Re: State Significant Development Application – SSD 10321 – John Whiteway Dr, Gosford

Attachment A: CCLHD Health Promotion Service submission re Environmental Impact Statement (EIS) for State Significant Development Application (SSD-10321) under Part 4 of the Environmental Planning and Assessment Act 1979 (EP&A Act) relating to a residential development at 89 John Whiteway Drive, Gosford.

ATTACHMENT B: CCLHD Public Health Unit submission on State Significant Development Application (SSD-10321) EXH-2802, Residential Development 89 John Whiteway Drive Street, Gosford May 2020.

Figure 9 | Proposed public walkway and viewing platform (Base Source: Distinctive Living Design)

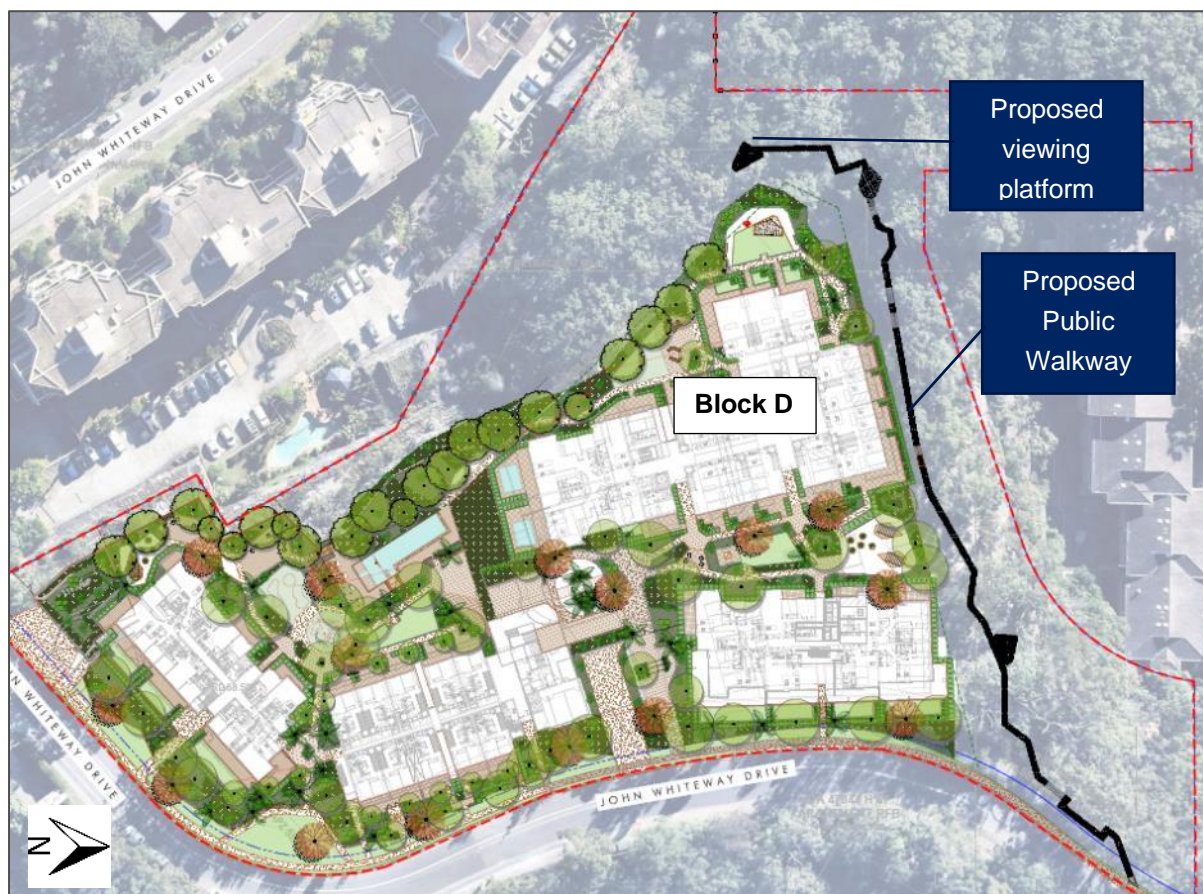
- EIS
 - 3.6 Landscaping and Public Domain
 - 3.6.1 Public Through Site Link and Viewing Platform – We commend the proponent's commitment to provide public pedestrian access through the site. To ensure this facility is truly accessible, we recommend adherence to best practice accessibility and Crime Prevention Through Environmental Design (CPTED) guidance is required as a condition of development consent. Refer also to comments regarding 5.7.3 Pedestrian Access.
